## Planning Consultation Memo

<b>Date</b>	<b>Planning Officer</b>	<b>Environmental Health Officer</b>
12/06/18	Clare Howe	Karl Riahi
<b>Planning Application Number</b>	<b>Worksheet Number</b>	
6/2018/1057/FULL	WK/97895

**Address:** Fountain House 1-7 Howardsgate Welwyn Garden City AL8 6AL

**Application Details:** Construction of a dormer roof formation to accommodate an additional storey at third floor level, providing nine flats (7 x 1 bedroom and 2 x self-contained studio flats), including a rear lift tower, ground floor entrance lobby, and external services serving the new floor.

Figure 1 provides an extract of a section drawing annotated to illustrate the assessment location in relation to the condenser unit location.

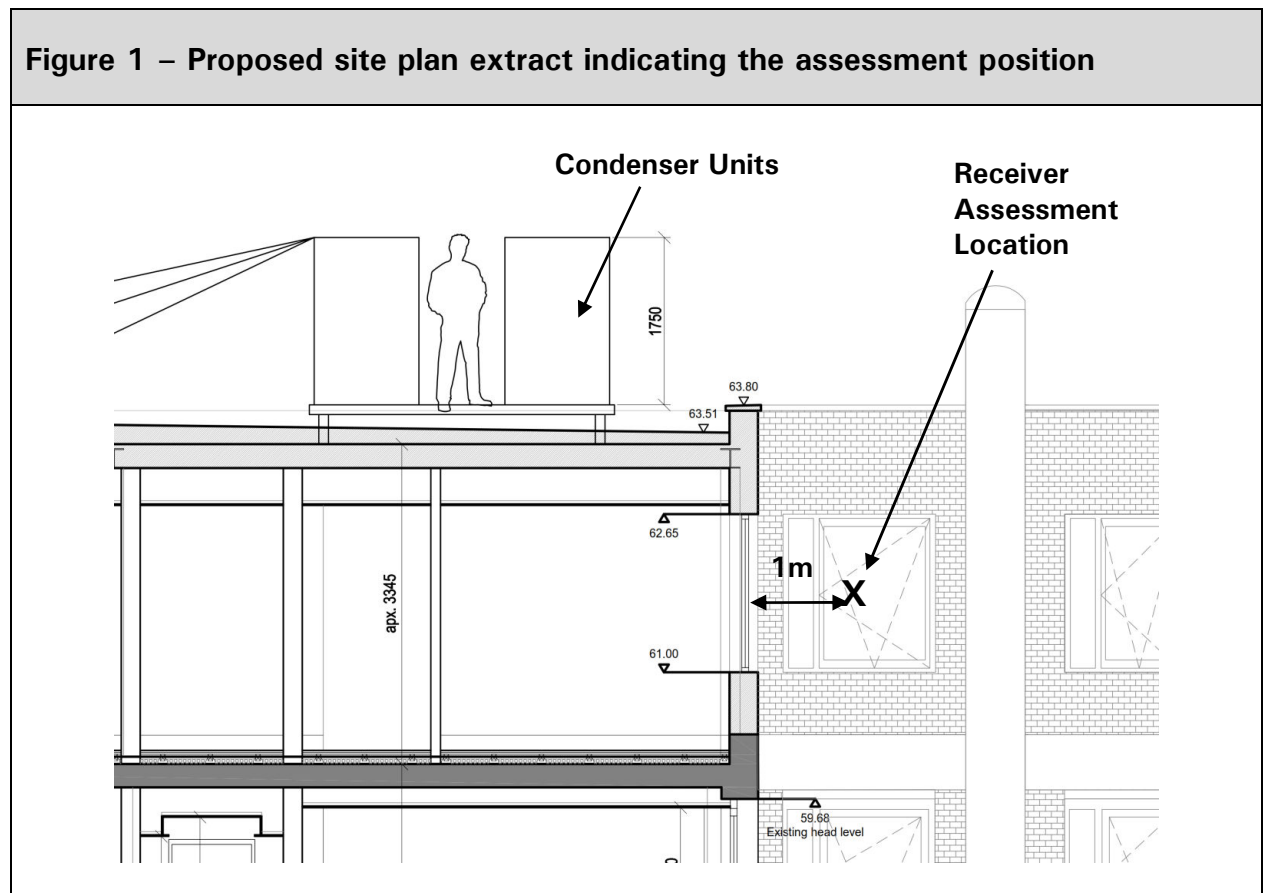
An acoustic report provided with the application shows that the proposed plant will be 17dB below the background noise level at the nearest sensitive receptor, as such, this shows that noise from the proposed rooftop plant will be very unlikely to cause complaints.
